DECISION DELEGATED TO HEAD OF PLANNING

Application No: H16-1092-25 **Applicant:** M Antonica & T Costianu

Proposal: Erection of two storey side extension with attached garage, garage conversion, internal alterations & erection of boundary wall & gate

Location: 57 Aintree Drive Spalding Lincolnshire

Drawing name:  
Boundary wall details:  
As Proposed

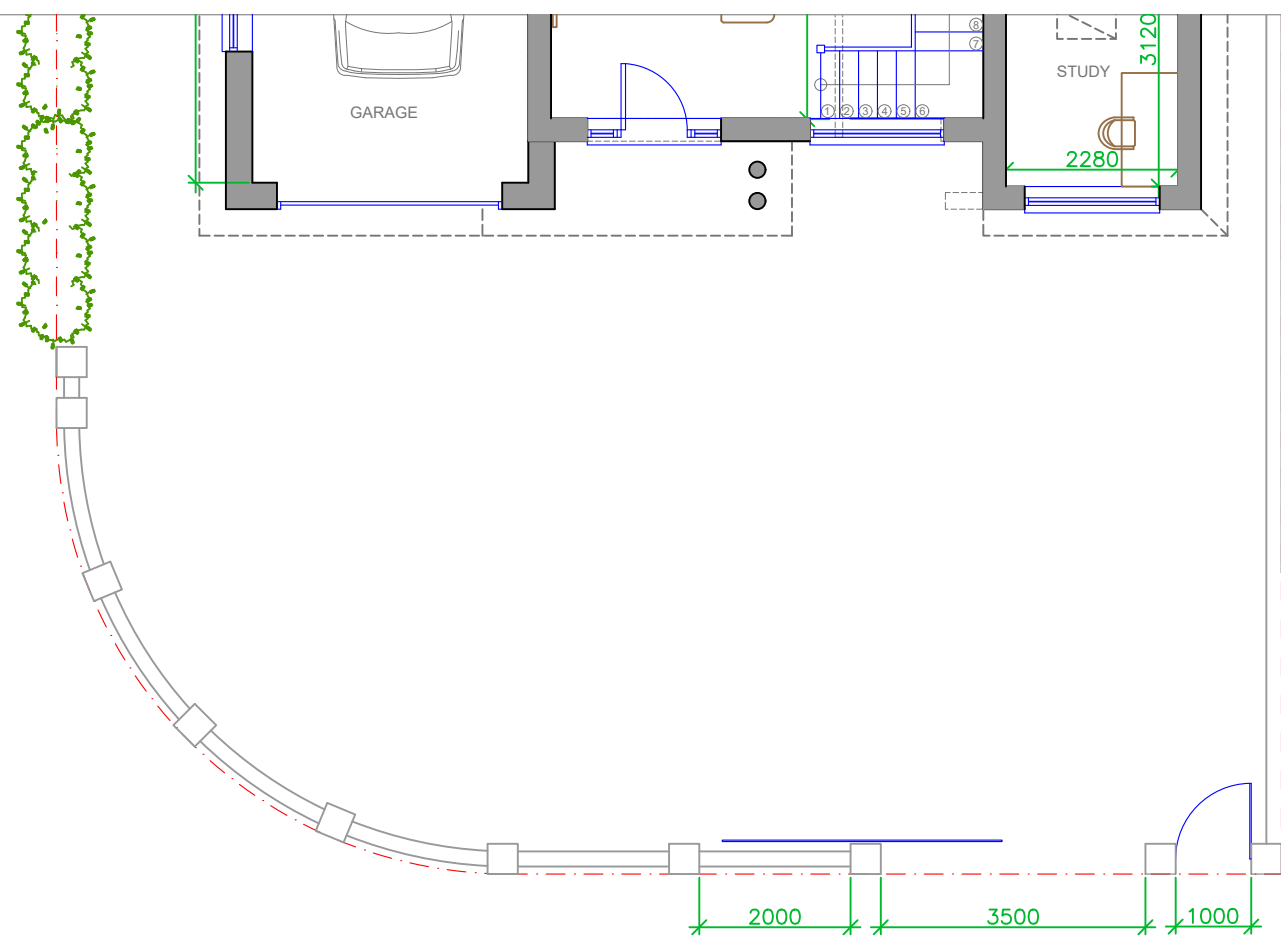
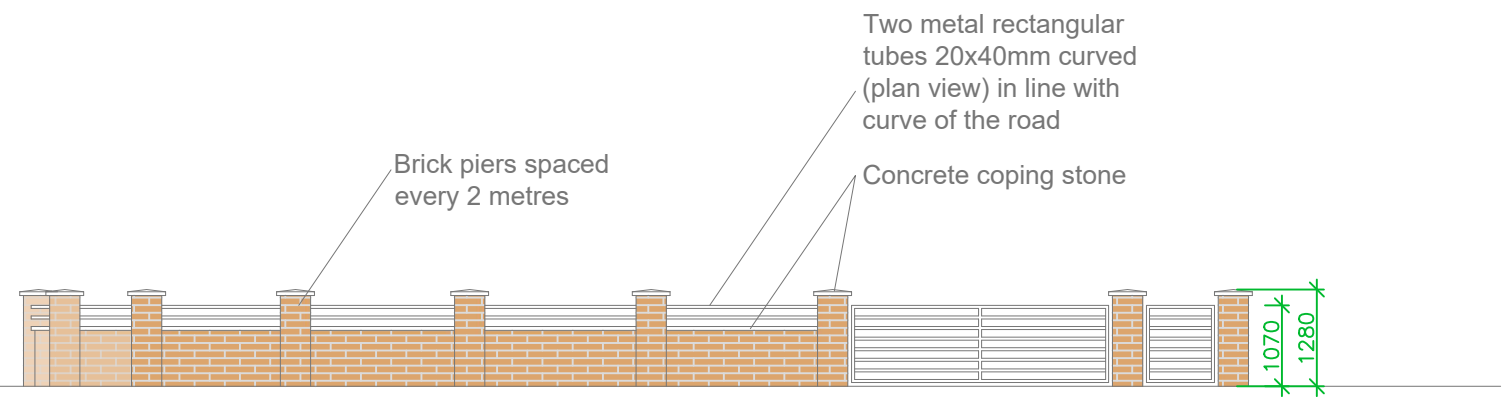
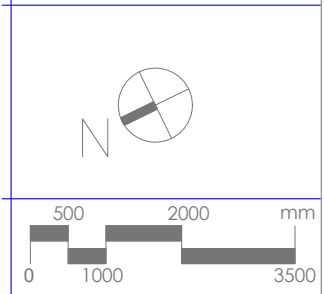
The proposed wall would only be marginally taller than what could be achieved via development permitted under Schedule 2, Part 2, Class A of the General Permitted Development Order, 2015. The Order does not restrict material choices for boundary treatments. Whilst it is felt that the

boundary treatment would impinge upon the sense of openness in the area currently, in light of this fallback position and the marginal level of difference between the proposal and the Order, it is felt that it would be inappropriate to resist the application on this basis.

Drawing name:
Rear Elevation: As Existing + As Proposed

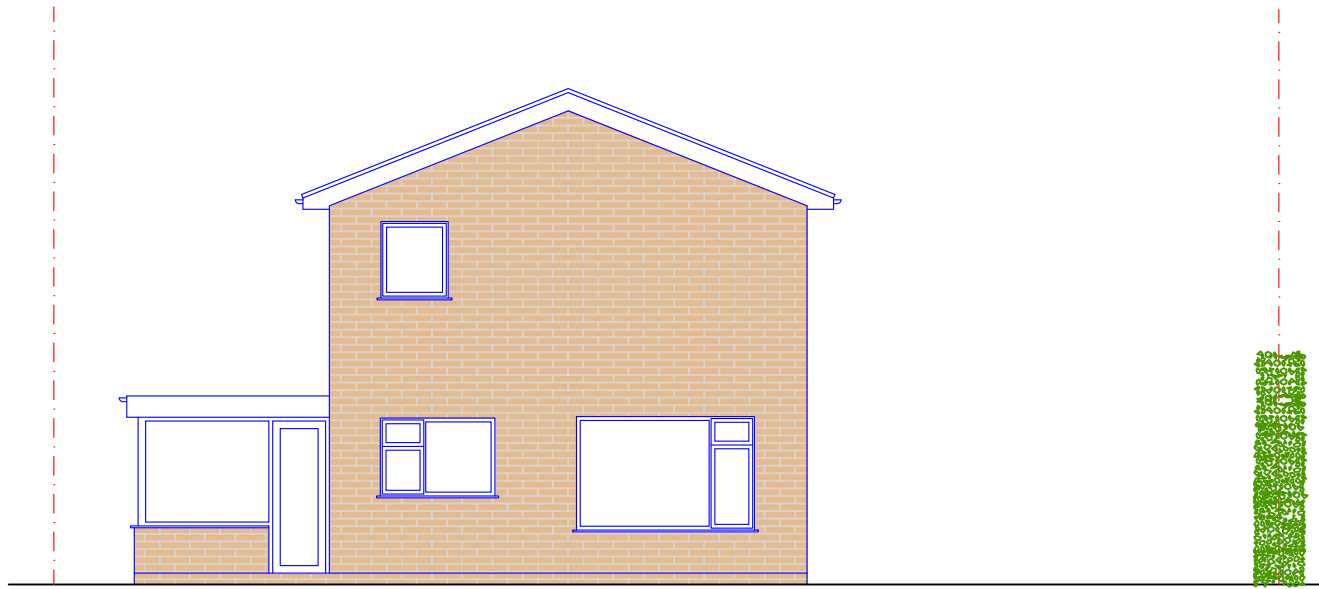
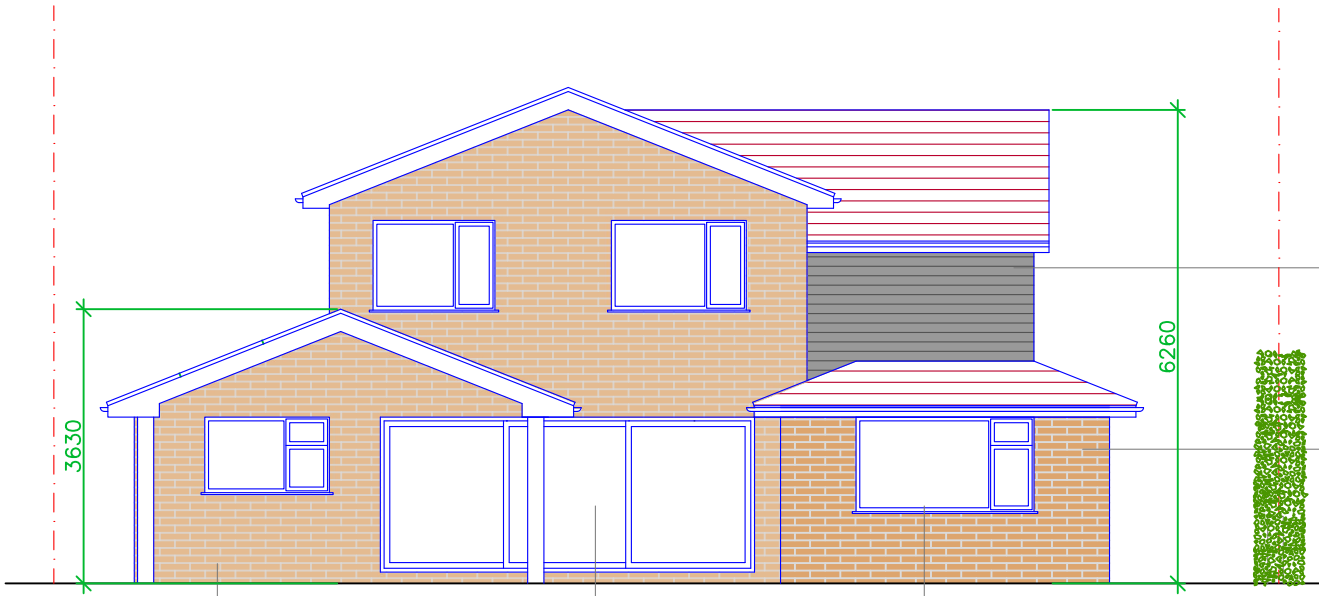
The first floor extension fails to properly integrate itself into both the host dwelling and the wider area. The materials selected are entirely atypical, failing to reflect existing design choices. The proposal would therefore fail to adhere to Paragraph 57 of the NDG, which states: "Materials, construction details and planting are selected with care for their context. They are attractive but also practical, durable and affordable. They contribute to visual appeal and local distinctiveness".

Moreover, the scale and positioning of the first-floor extension relates awkwardly to the existing plot and wider area. Larger first-floor extensions of this nature, which due to the use of alternatively materials would read almost as an enlarged dormer, are not abundant in the immediate setting. The proposal would therefore break from the existing uniformity, with the effect of this emphasised by the prominent positioning.

When taken as a collective, including the creation of the overhang, the resultant scale of the building would far exceed surrounding dwellings. As a result, the dwelling would appear overly large within its plot, and would fail to reflect the built form of the area.

Drawing name:  
Side Elevation: As  
Existing + As Proposed

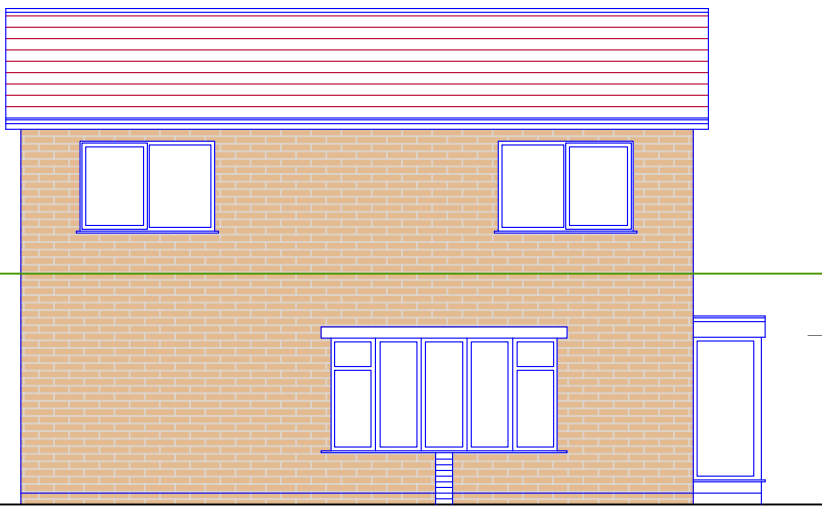
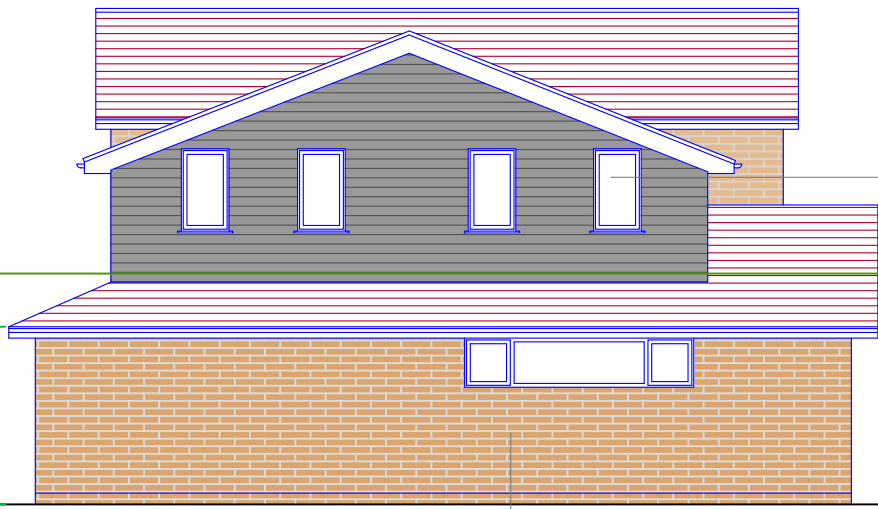
The positioning of the extensions, towards the corner with Ascot Close, would significantly increase the visibility of the extensions, and therefore their impact upon the character of the plot. Placing the extensions towards such a visible point would increase their perceived bulk further. Given that the extensions are already relatively large, when compared to the existing dwelling, the result is a dwelling which would appear overly large and bulky within its setting. This in turn would result in the dwelling appearing incongruous in its setting.
